**Application Reference: 2026/0295**

**Site Address:** 3 Rydal Close, Penistone, Sheffield, S36 8HN single storey front extension, conversion of integral garage to habitable area, 2 storey rear extension, widening of driveway to create extra parking space, removal of rear single detached garage and replace with detached double garage and alterations to fenestration and doors to dwelling.

Drawing Title: Site Plans - EXISTING & PROPOSED

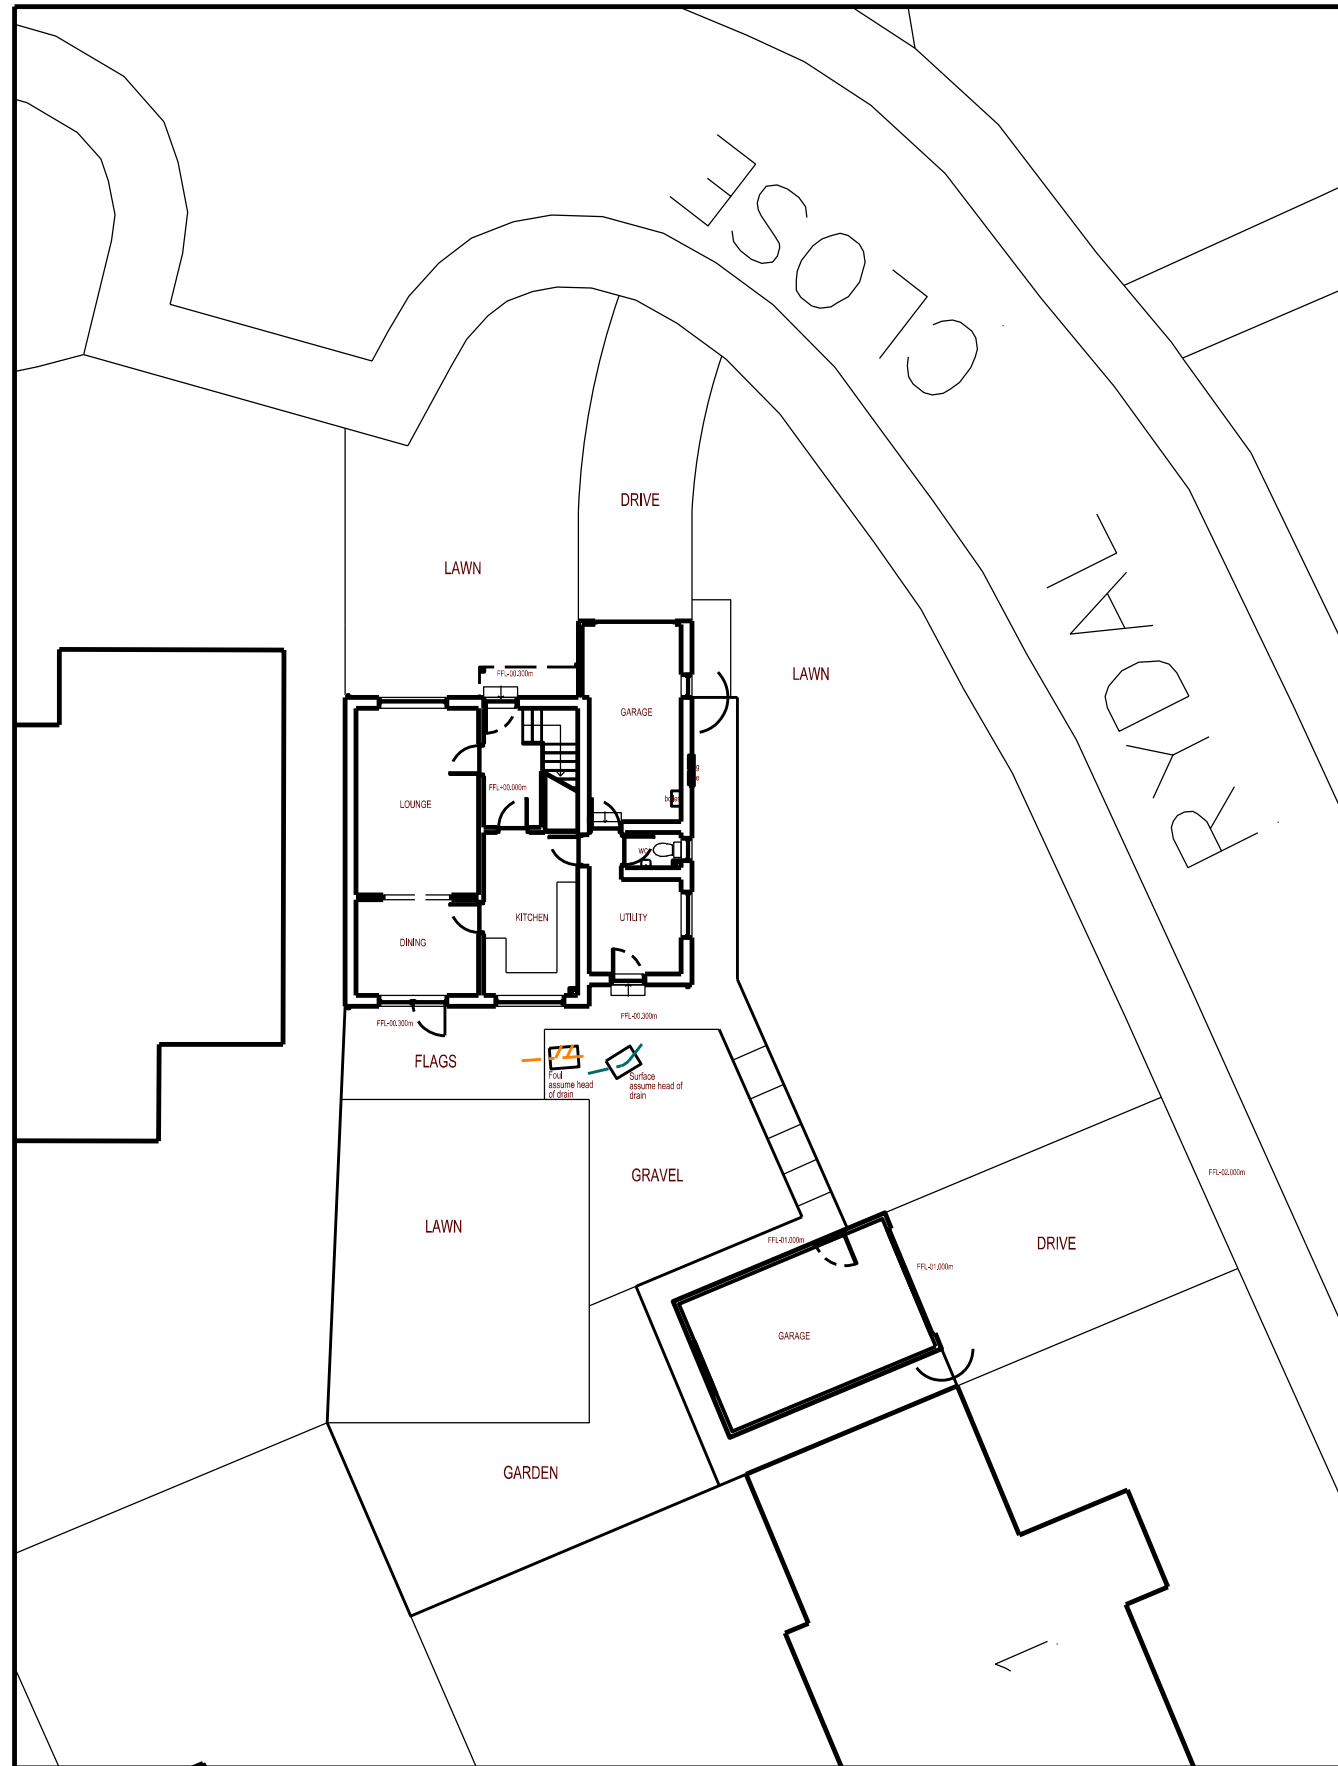
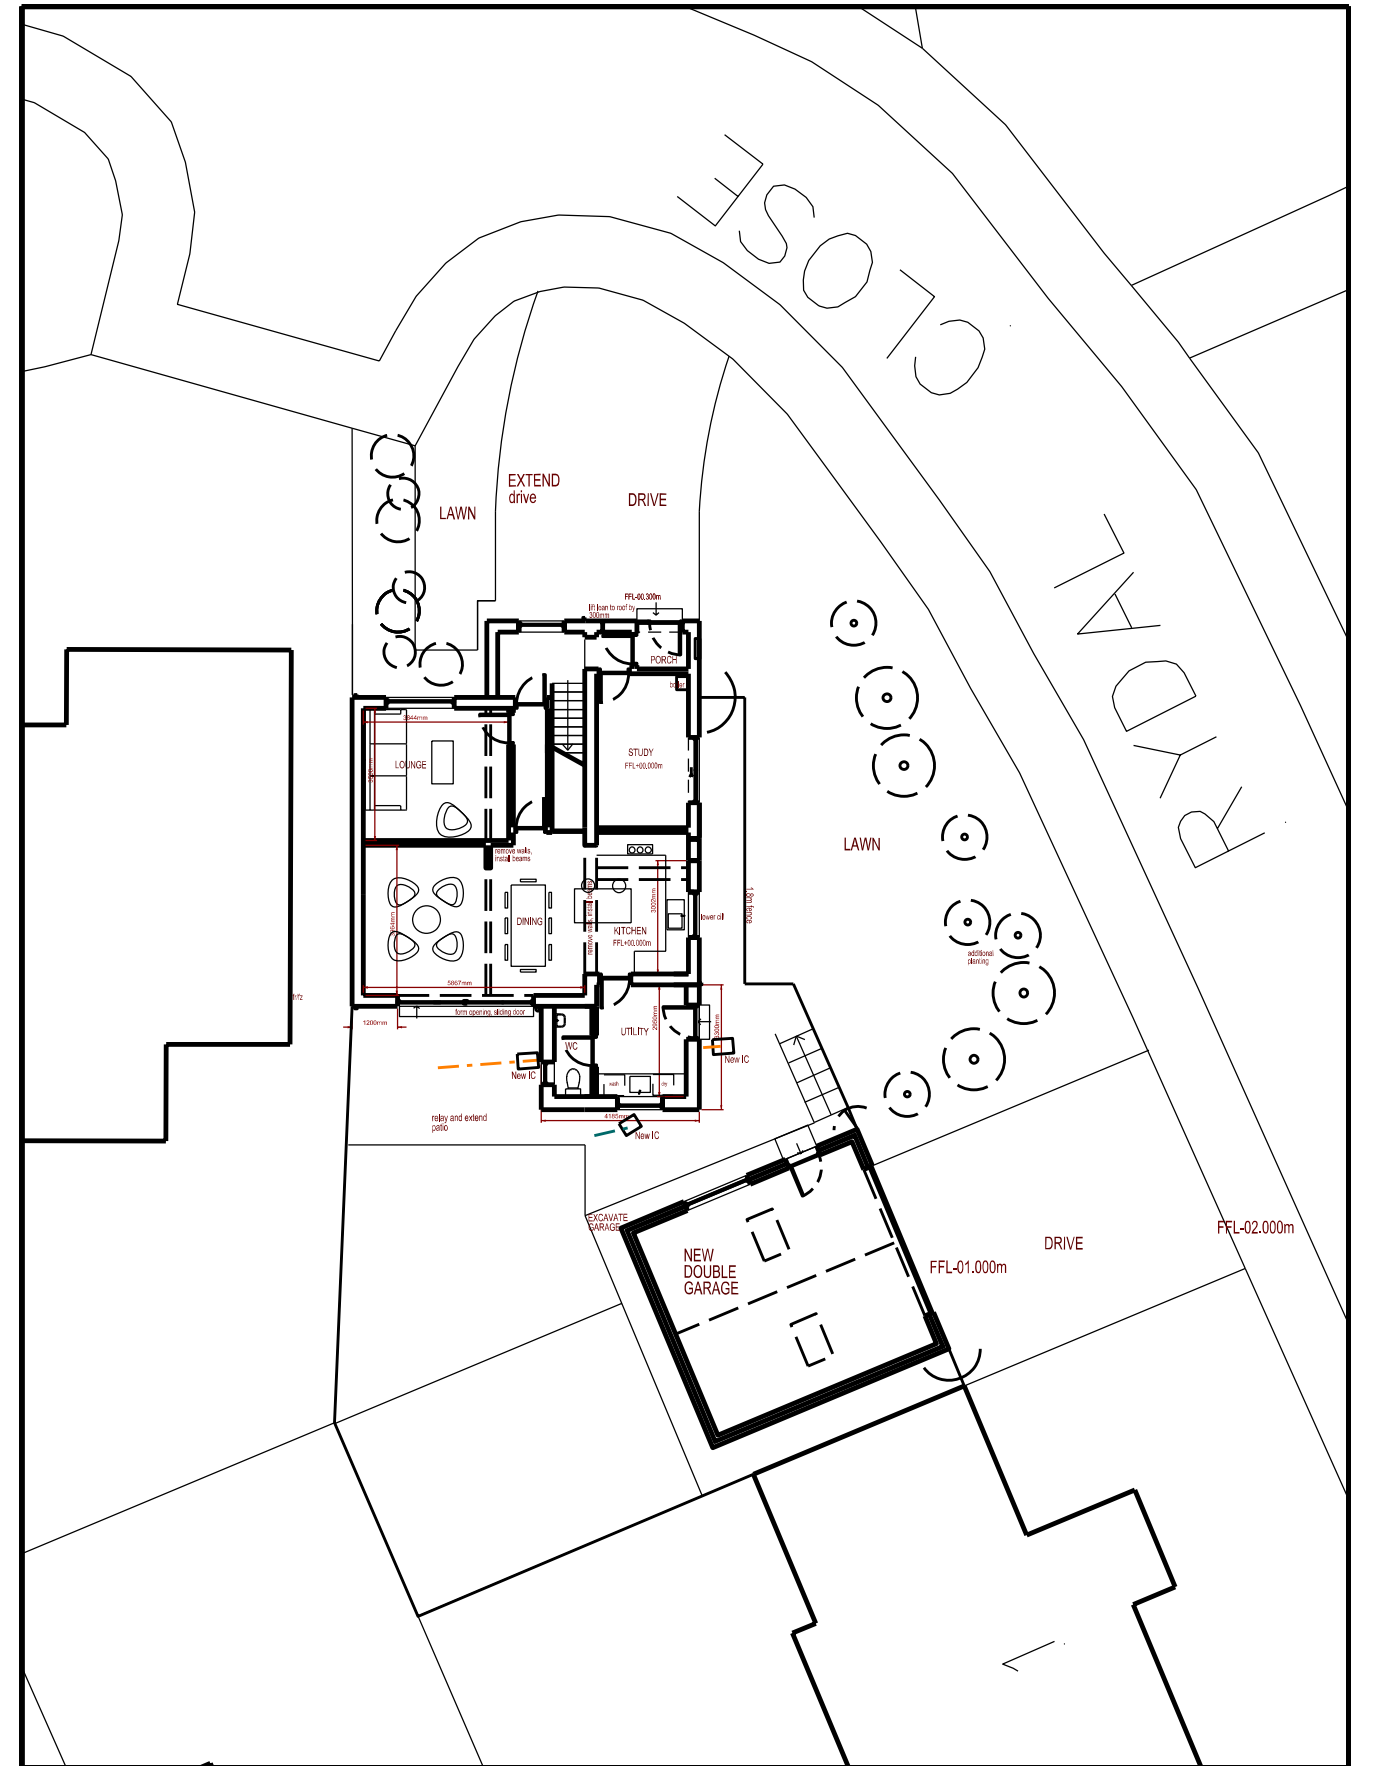
Also indicated on the plans is relocation and replacement of two excising drains, presumably drain manhole covers/inspection chambers. Three new inspection chambers replace the existing two drains. A bi-fold door is also replaced with a sliding door of similar size. There are also some minor internal changes including resizing of the first-floor bathroom.

Starting with the garage and ground works, the proposed demolition of the original garage has already occurred and construction of the replacement garage and other ground works including the widened driveway has started. With the garage scale and design mirroring that approved in applications 2025/0254 and 2026/0333, once completed the garage and ground works would have no further impact on the design, scale or character of the dwelling other than that what was originally assessed and subsequently approved in applications 2025/0254 and 2026/0033.
